# KITTITAS COUNTY FIRE MARSHAL'S OFFICE

September 29, 2016

Re: Mostofi (VA-16-00001)

VA-16-00001

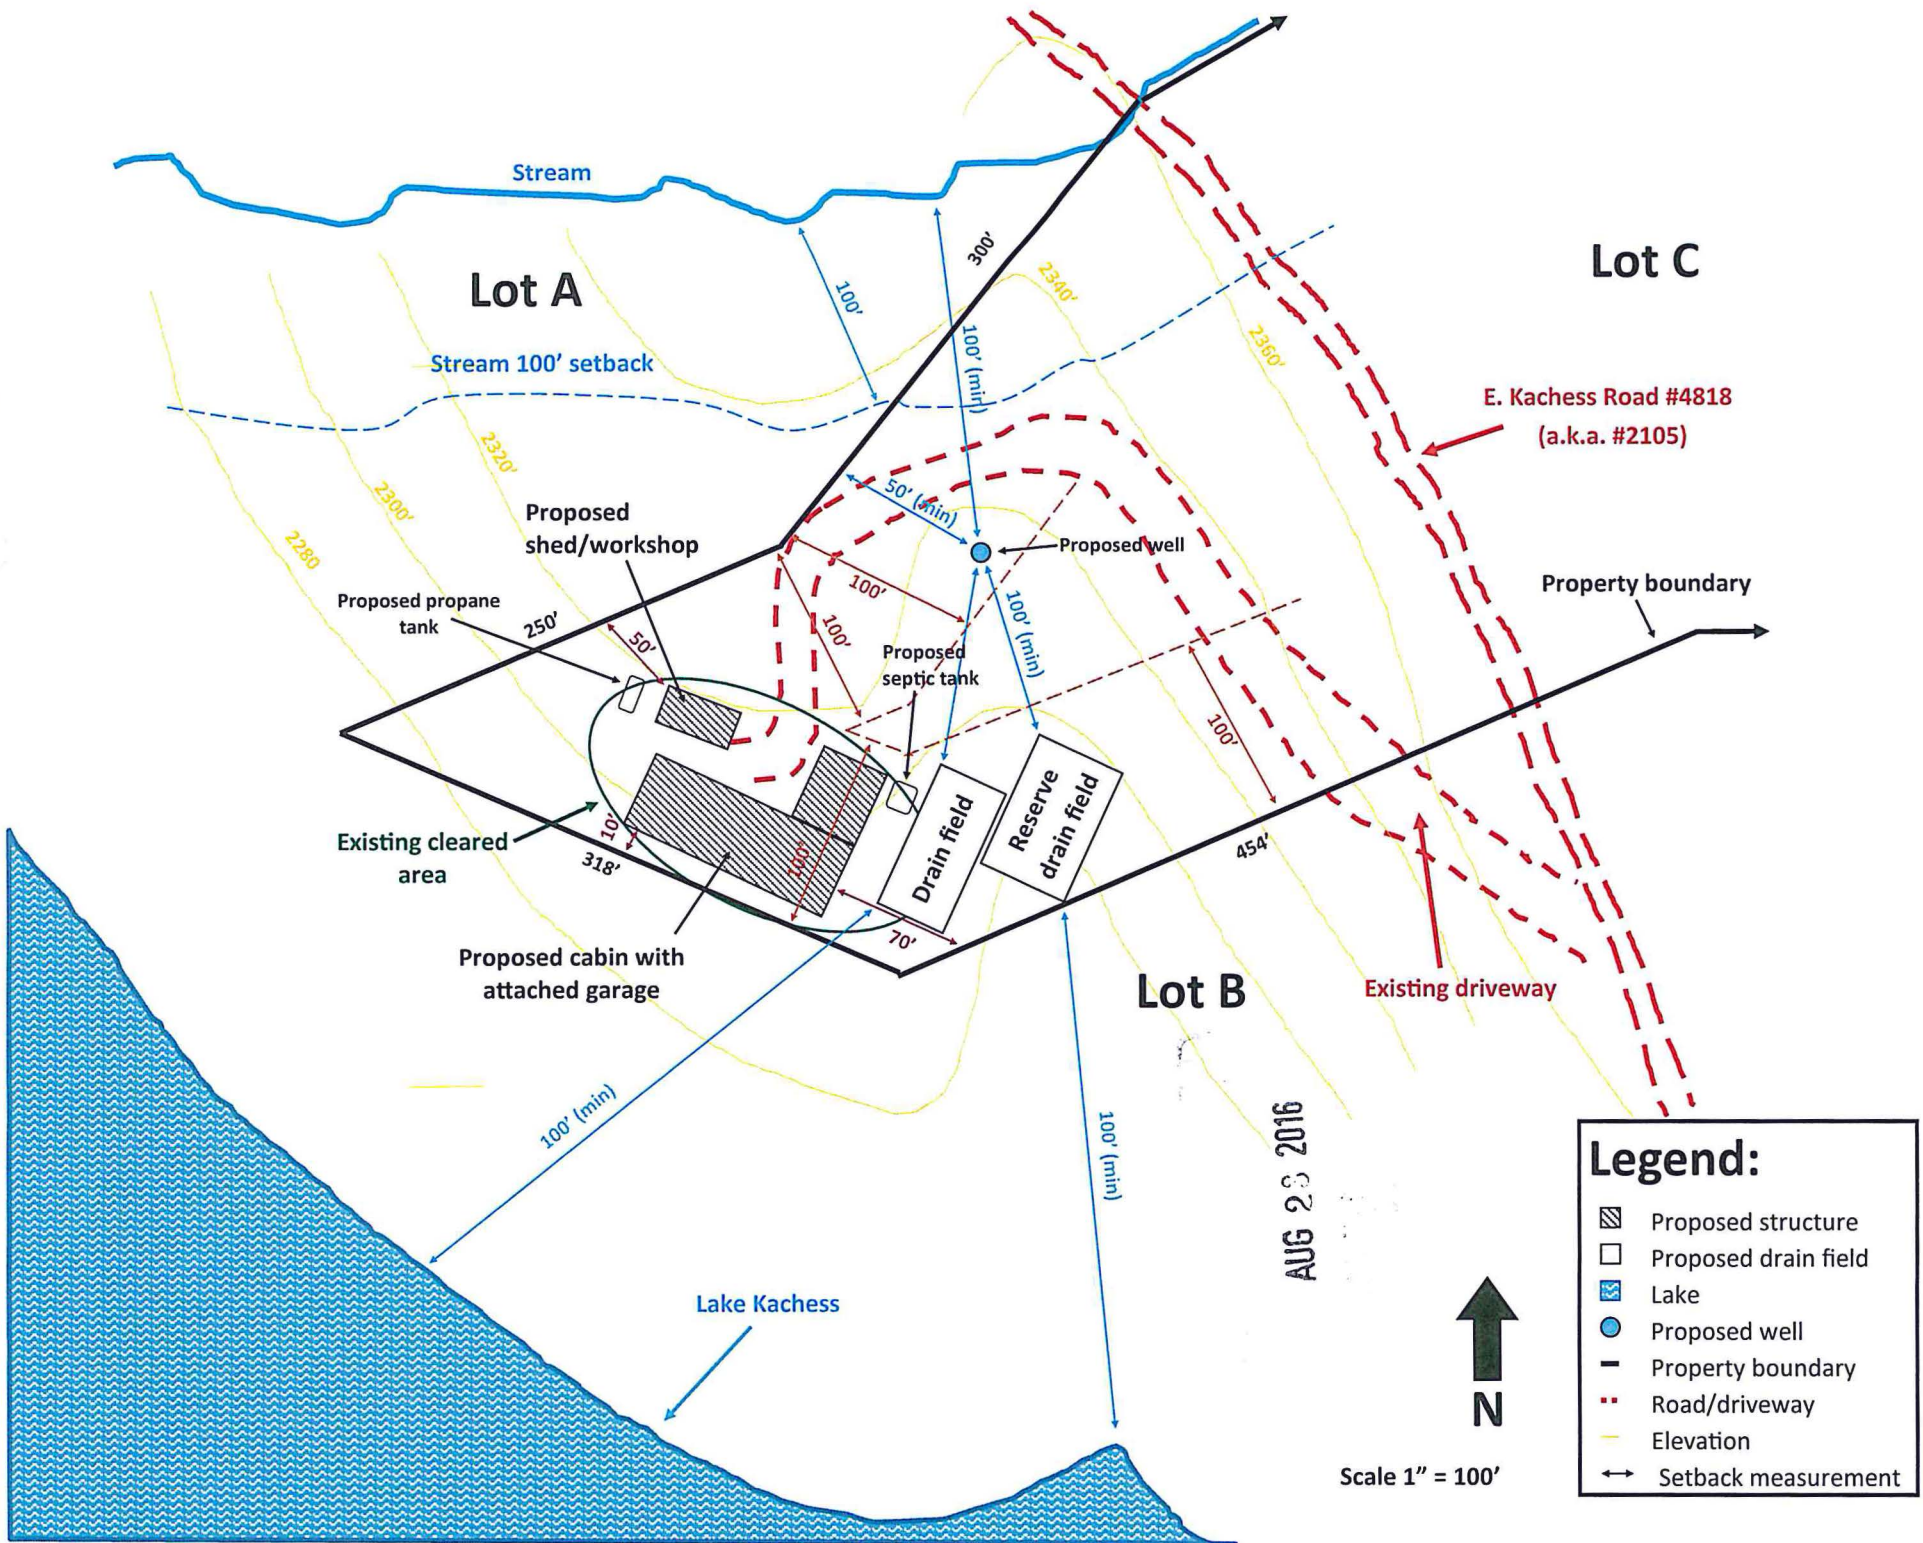
- Any new driveway must comply with Kittitas County Code, i.e. driveway lengths over 150' are have a width of no less than 16 feet.
- All new construction must meet the Wildland Urban Interface (WUI) Code for building components and defensible space.
